Comment from Greenspace

NOTIFICATION FROM ARUN DISTRICT COUNCIL
Town & Country Planning Act 1990 (as amended)
Town and Country Planning (Development Management Procedure) (England) Order 2015
Planning Permission
APPLICATION NO: **BE/27/20/PL**

Registered: 23rd March
2020
Site Address: Land at Salt Box West of Shripney Road Bersted
Grid Reference: 493510 101932
Description of Works: Creation of temporary soil storage bund & haulage route associated with development of adjoining site at Saltbox (resubmission following BE/38/19/PL). This application may affect the character & appearance of the Shripney Conservation Area & is a Departure from the Development Plan.

TOP SOIL RELOCATION  
 SITE PLAN  
 1744-TS-P02-E

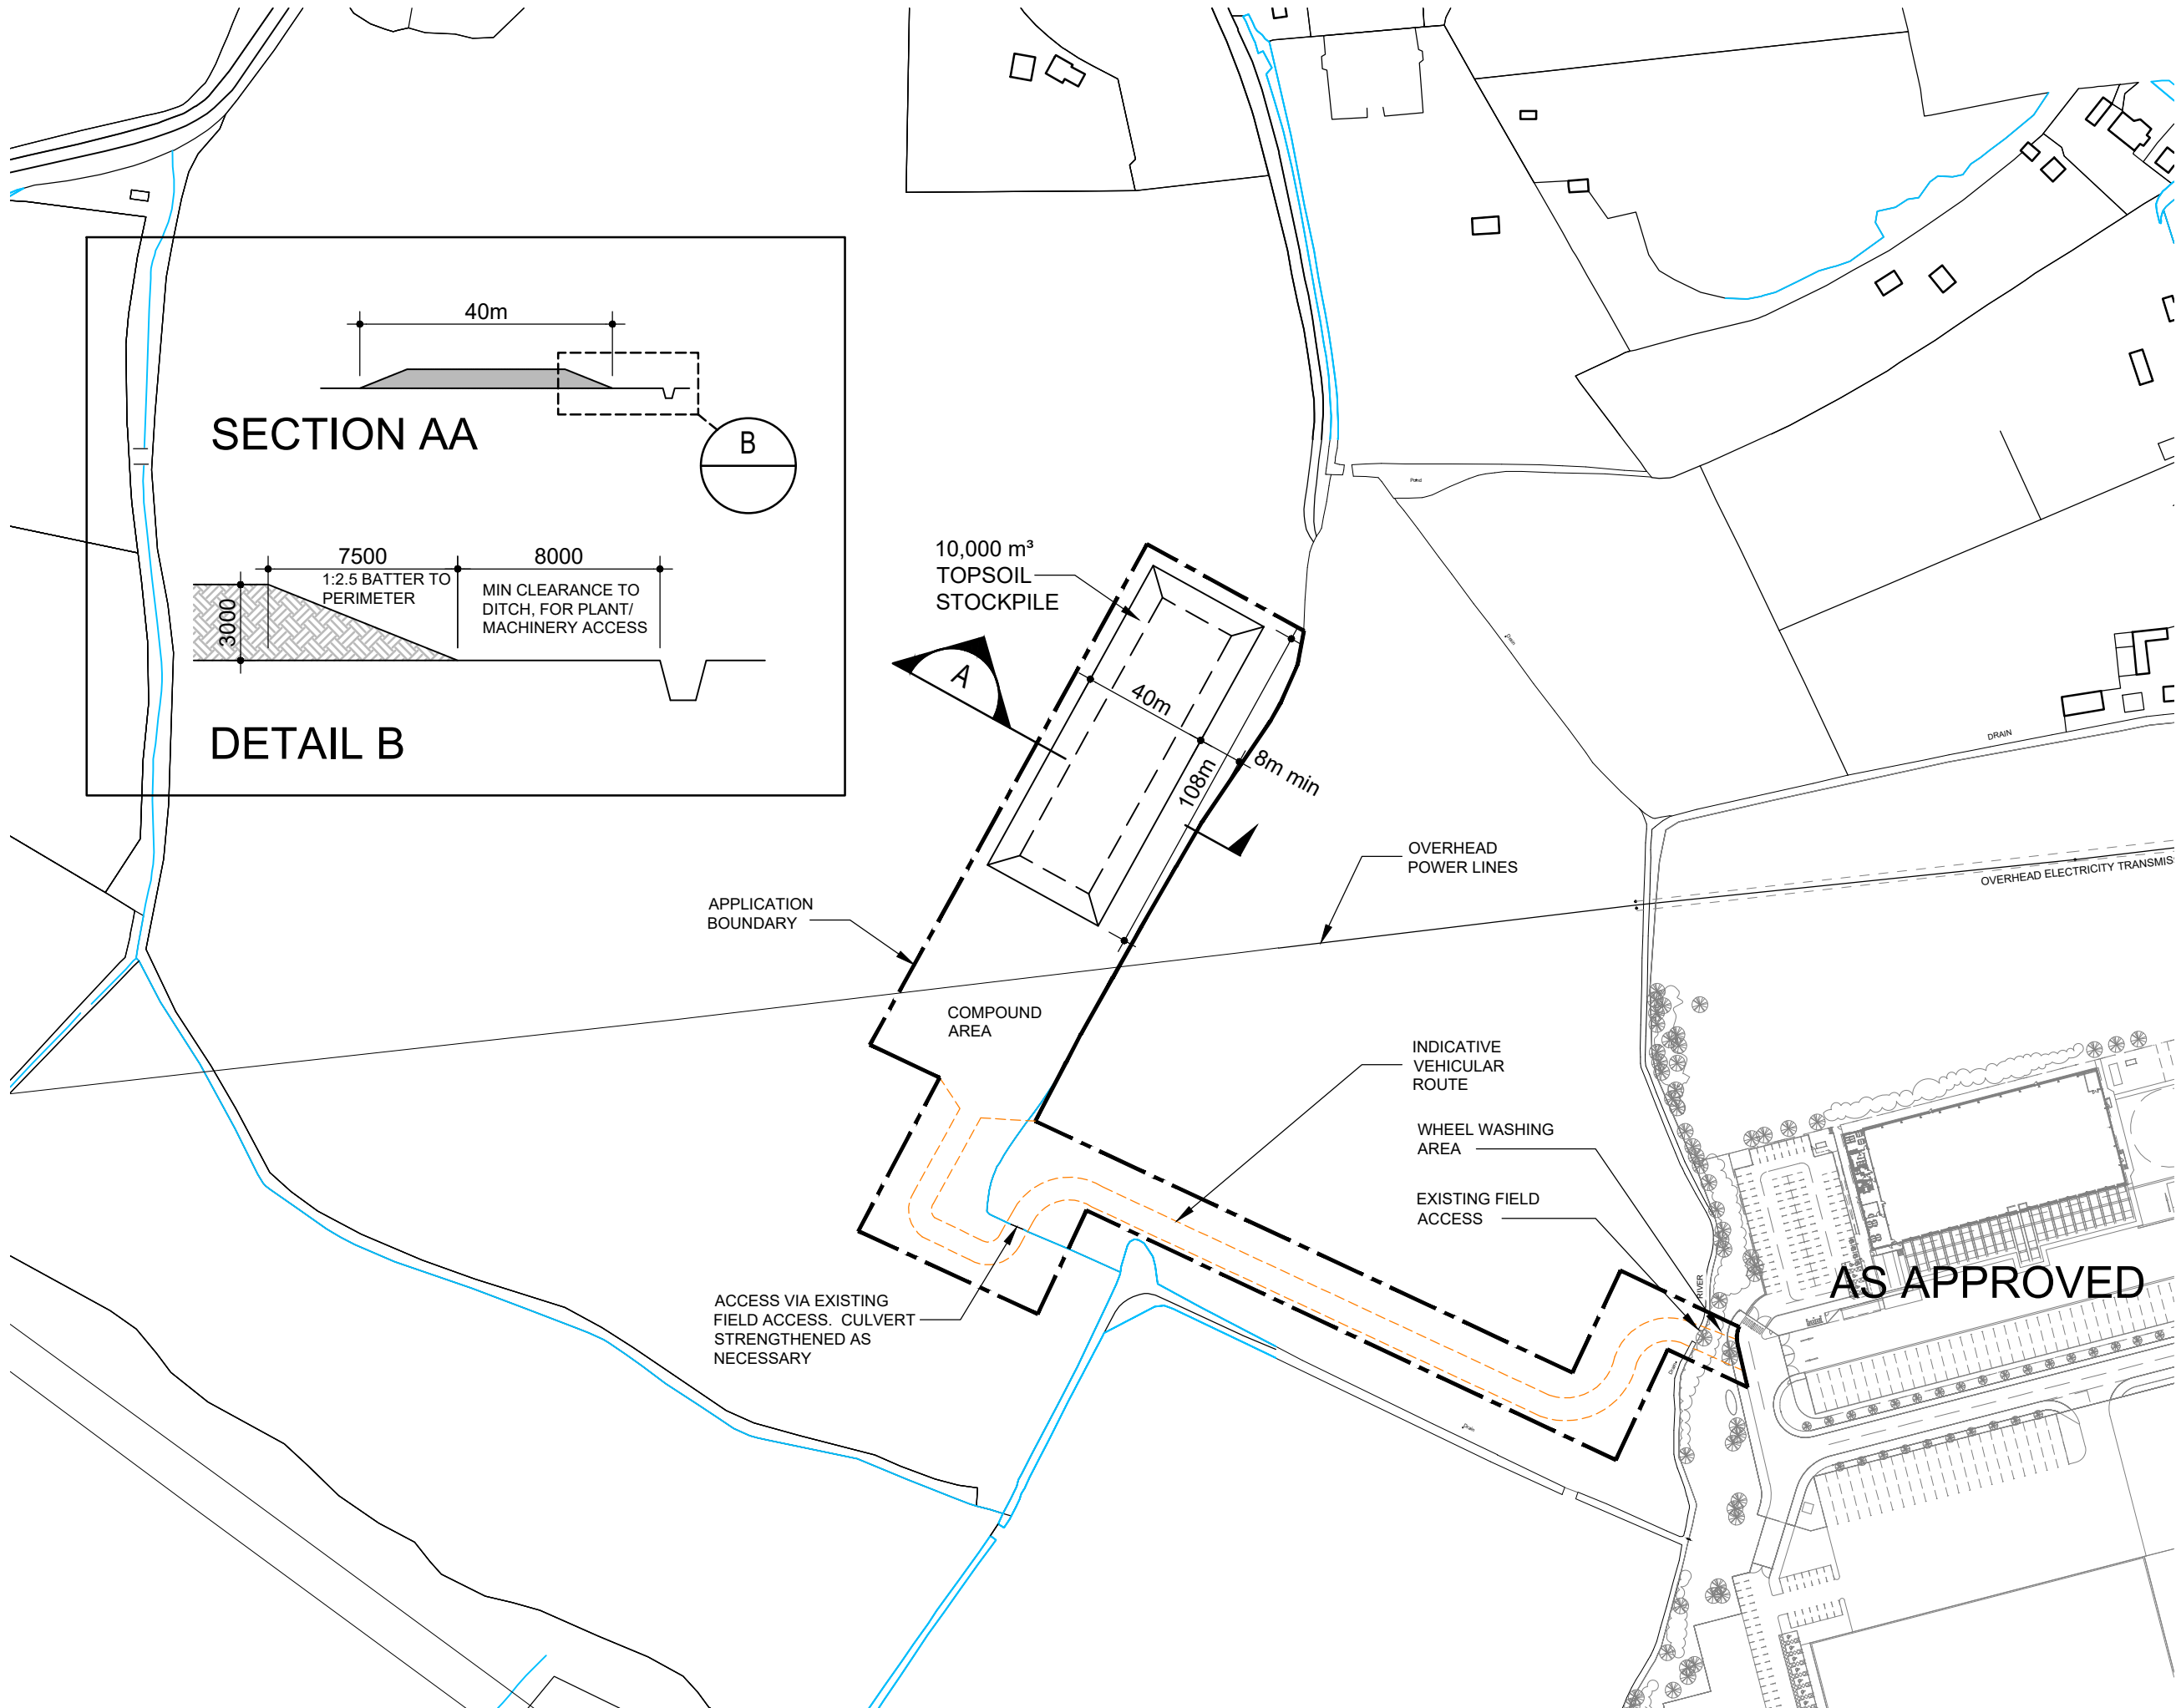
This application is for temporary stockpile of inert topsoil within existing field boundaries which are to be retained and protected and now with a 8.0m buffer (previously a 5.0 meter offset) to all watercourses save for the crossing point at the Salt Box site gate and will be largely unaffected by this temporary stockpile. Any widening of existing access will need careful management and any removed vegetation mitigated for on completion and reinstatement.

The visual impact of these re-submitted proposals due to the temporary nature of the works and the existing established vegetation structure should not pose significant harm to the landscape and visual environment. The maximum height of no greater than 3.0m x 40m wide x 108m long with 1:2.5 batter should be observed.

Topsoil and subsoil stripping operations should not allow for contamination by each other and the careful management at soil handling stage should be employed to ensure that this is the case.
